**ADC Planning Consultation  
Response from the Historic Buildings Adviser**

| <b>Application Number</b> | A/109/12/L                                                                          |
| <b>Address</b>            | Letterbox Cottage, Aldingbourne                                                     |
| <b>Description</b>        | Demolition of existing detached garage and erection of replacement detached garage. |

PROJECT			Proposed garage building at Letterbox Cottage Aldingbourne		
SUBJECT			Proposed Plans & Elevations		
SCALE	DATE	DRAWING No			
1:100	AUG 2012	2012.30.02			
DRAWN	CHECKED

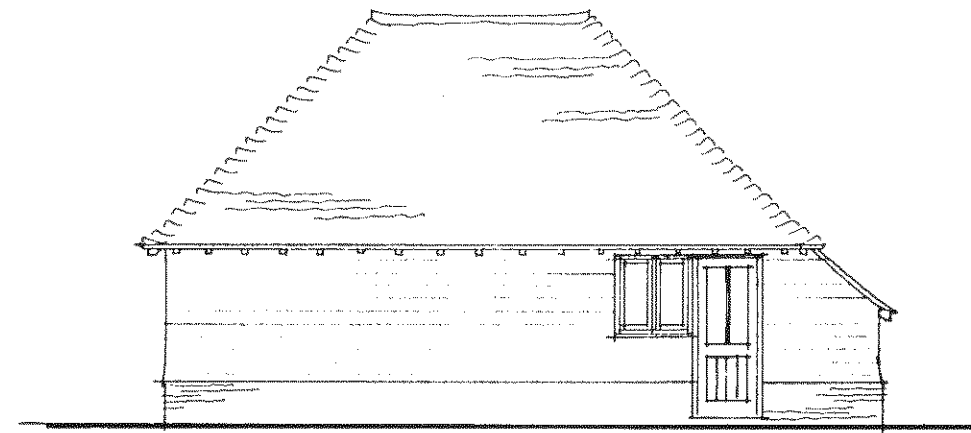
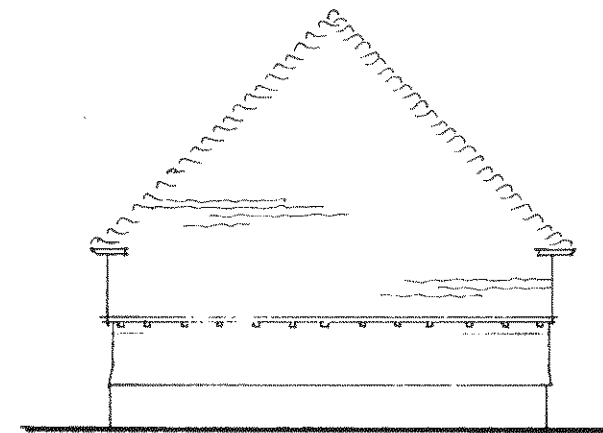
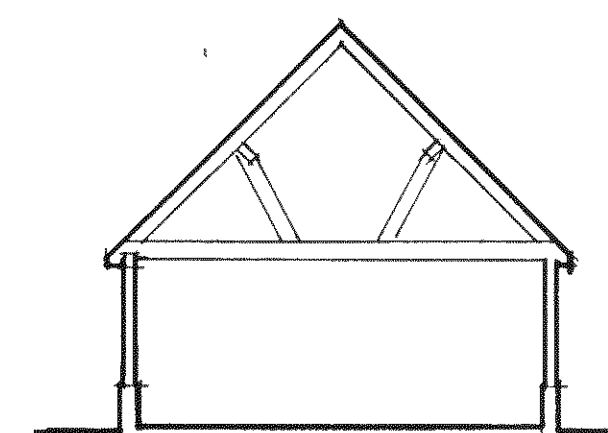
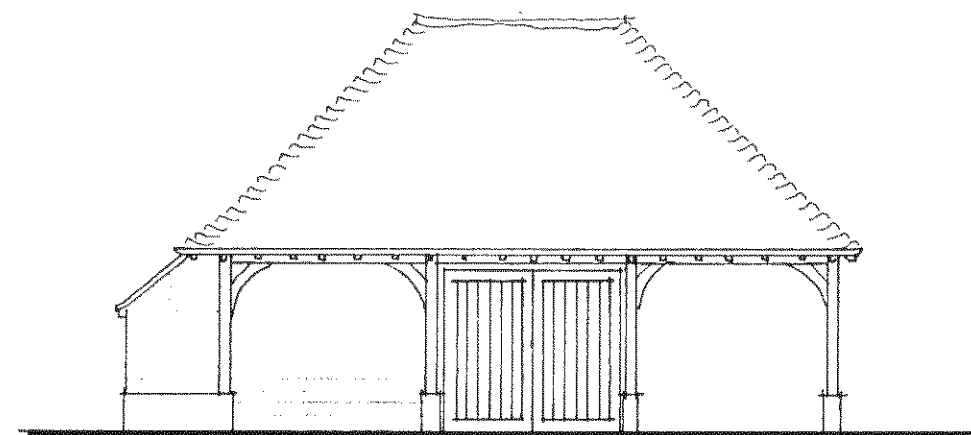
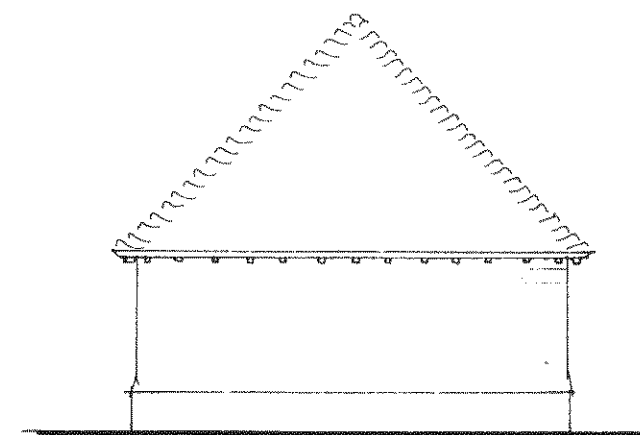
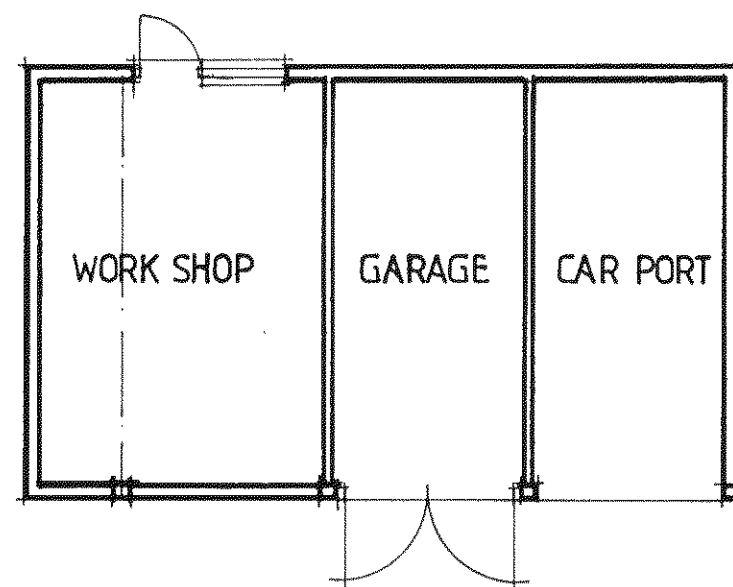
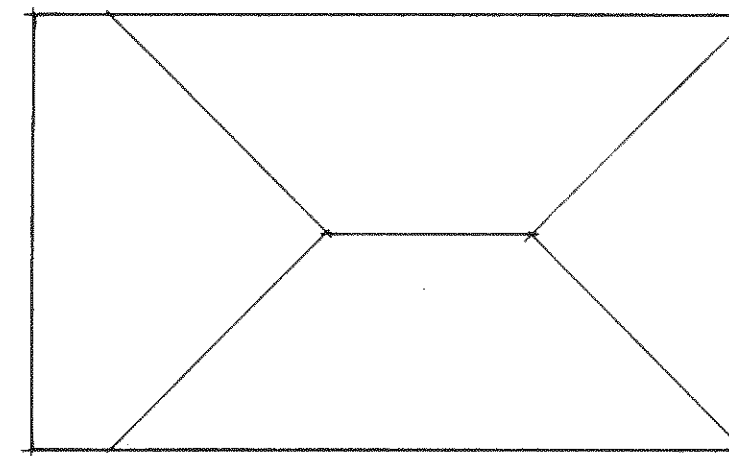
The removal of the wall is a major concern as it results in the loss of historic fabric as well as the sense of containment and separation which contribute to the setting of the listed building. This is evident on the 1<sup>st</sup> ed OS map of 1875 which appears to show this wall with further structures located approximately where the existing garage now sits. The wall is a feature of the site but also the broader context of the conservation area which is characterized by similar flint walls forming compartmented spaces. As such it should be preserved.

Whilst the siting of the garage is harmful because of its direct impact on the wall, the setting of the listed building is further harmed by the setting back of the garage into the garden. As the historic mapping shows, this area has not been developed and appears to have always been retained as garden. Of further concern here is the building scale which is not that much smaller than the main house on plan. This is caused primarily by the addition of a workshop to the garage and compounds the problem of building scale and visual impact. An elevation showing the cottage and garage should have been provided to assess this further.

The other related issue is the design of the garage/workshop which does not appear convincing in this context and the conservation area more generally. A pure timber structure of this type is not particularly common here and at this scale is likely to look incongruous. I would recommend that some masonry elements are introduced (if possible) and its siting retained as a more direct replacement of the existing garage.
